Application for a non-material amendment following a grant of planning permission.

SINGLE STOREY REAR EXTENSION

Reference number: WA/13/20/HH

CHANGING FRENCH DOORS AND SMALL WINDOW TO BI-FOLD DOORS.

Drawing No. BR220/588/3 A

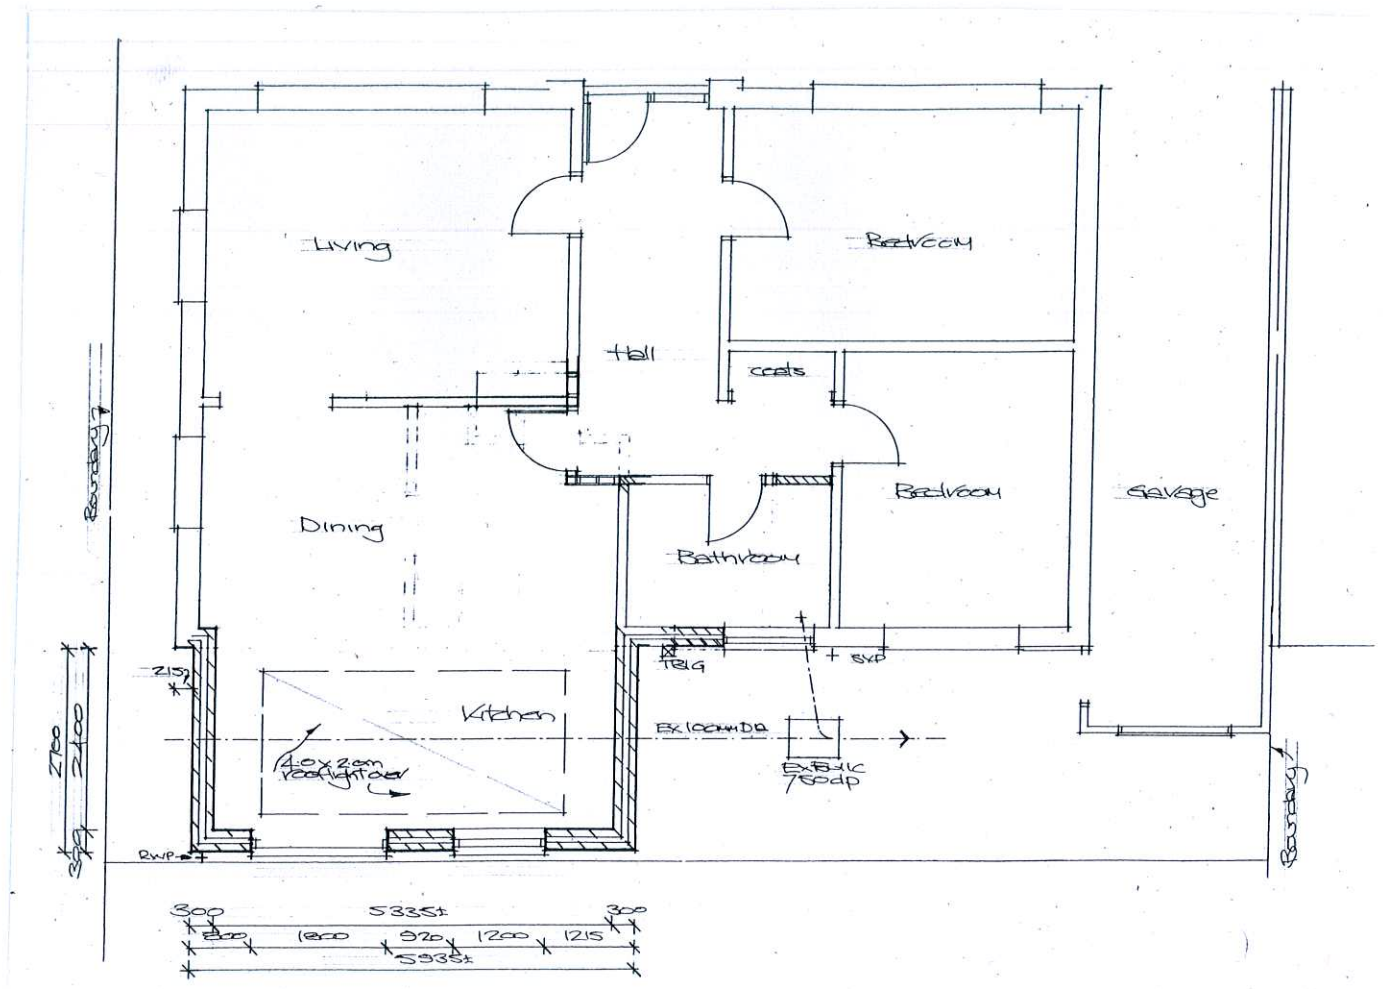
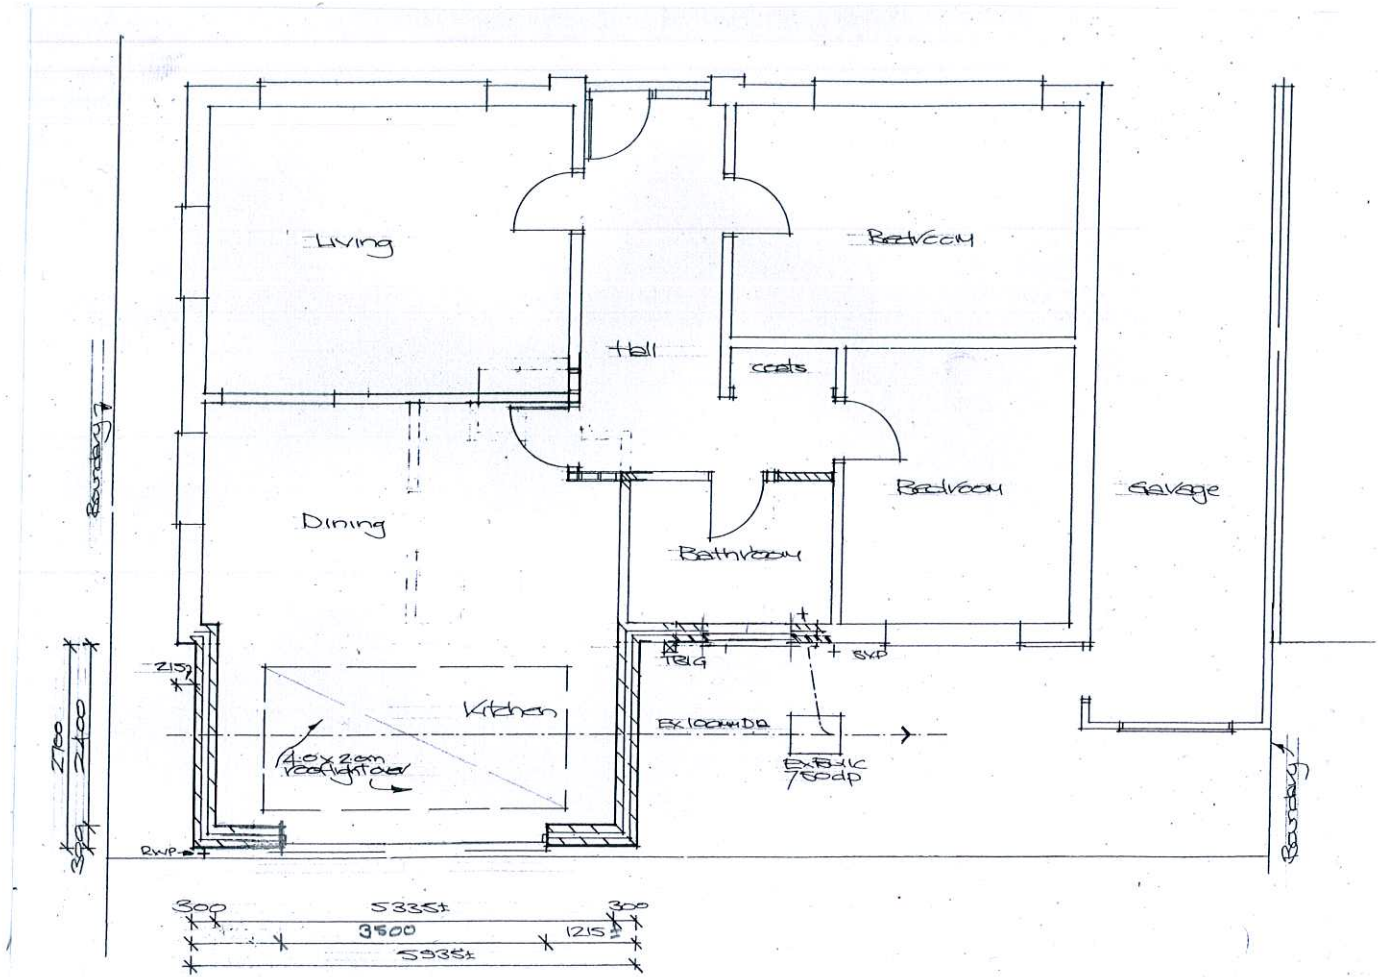
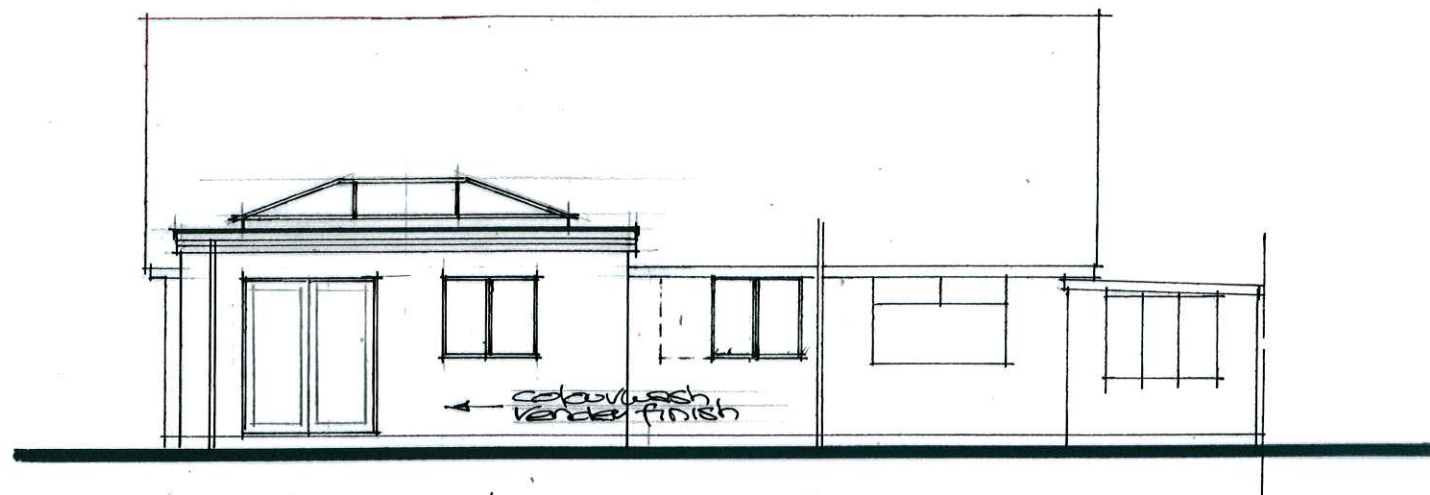
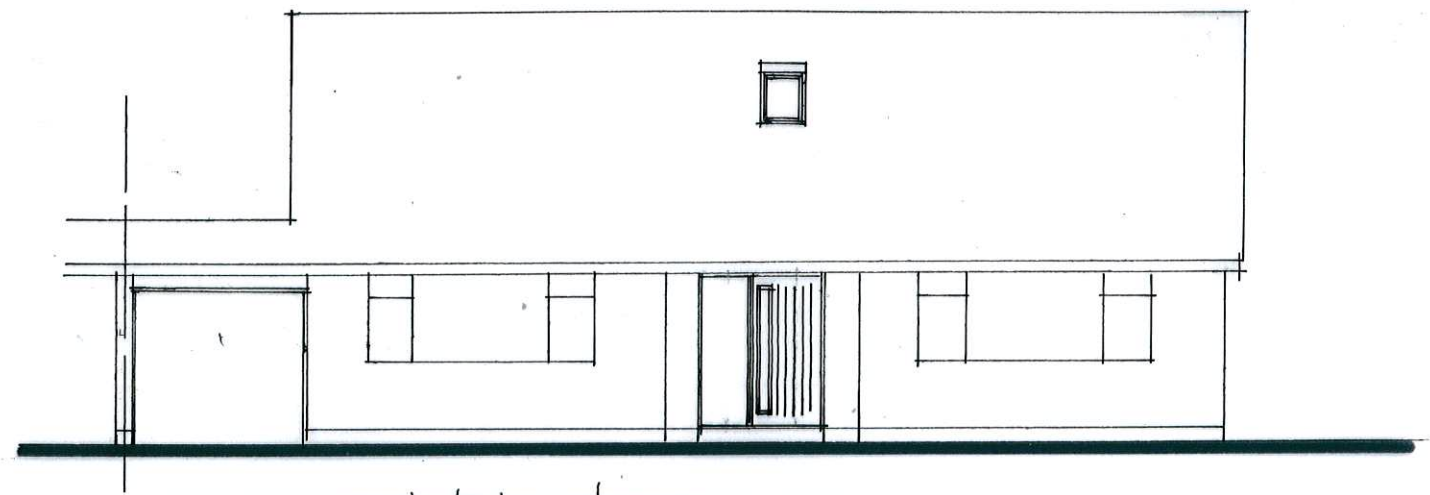
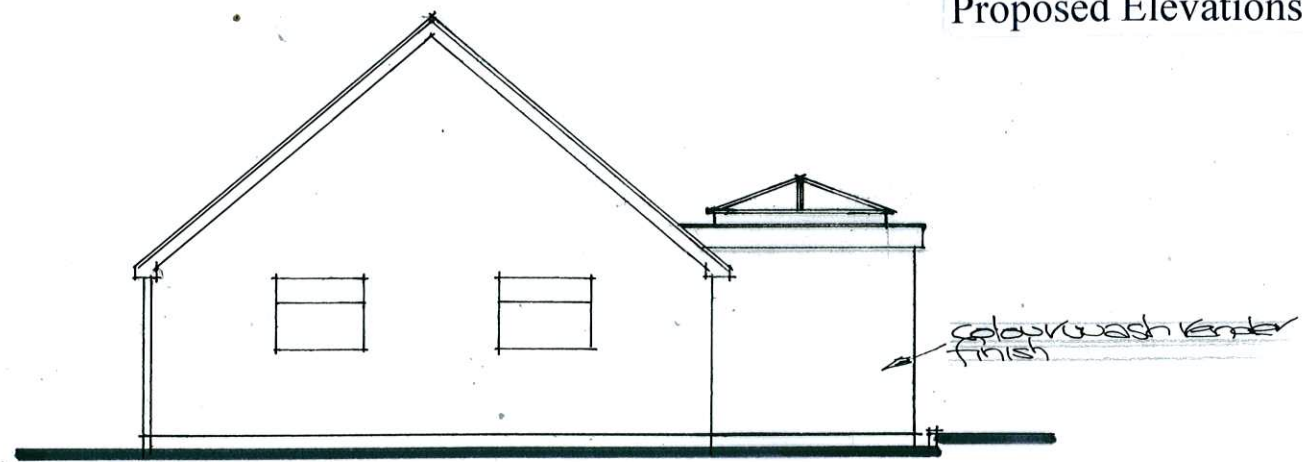
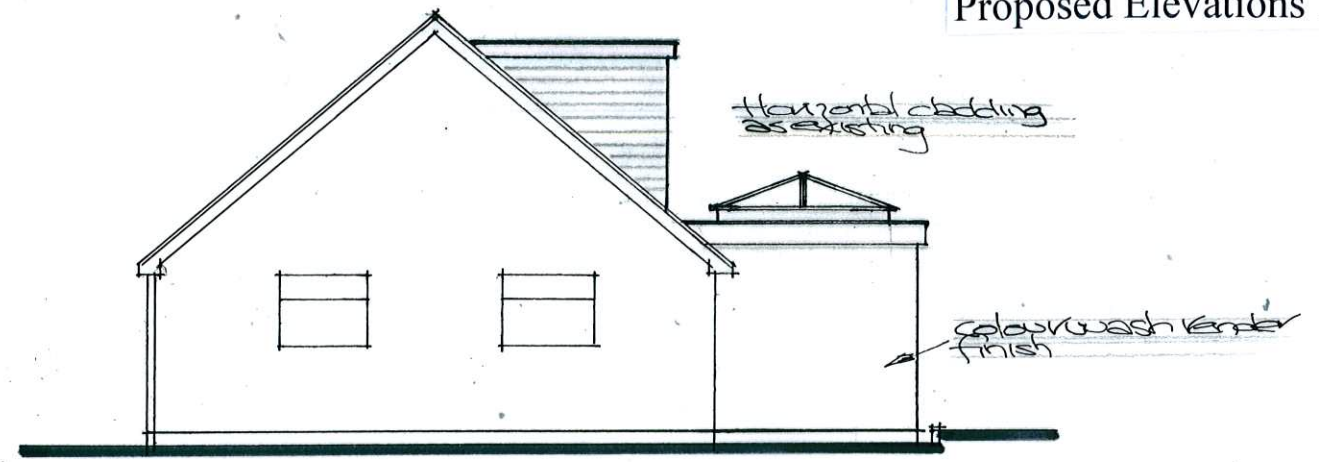
Old plan/drawing numbers

DRAWING NO. 220/587/3

New plan/drawing numbers

DRAWING NO. BR220/588/3A

TO IMPROVE INTERNAL LAYOUT AND EXTERNAL ARRANGEMENTS.
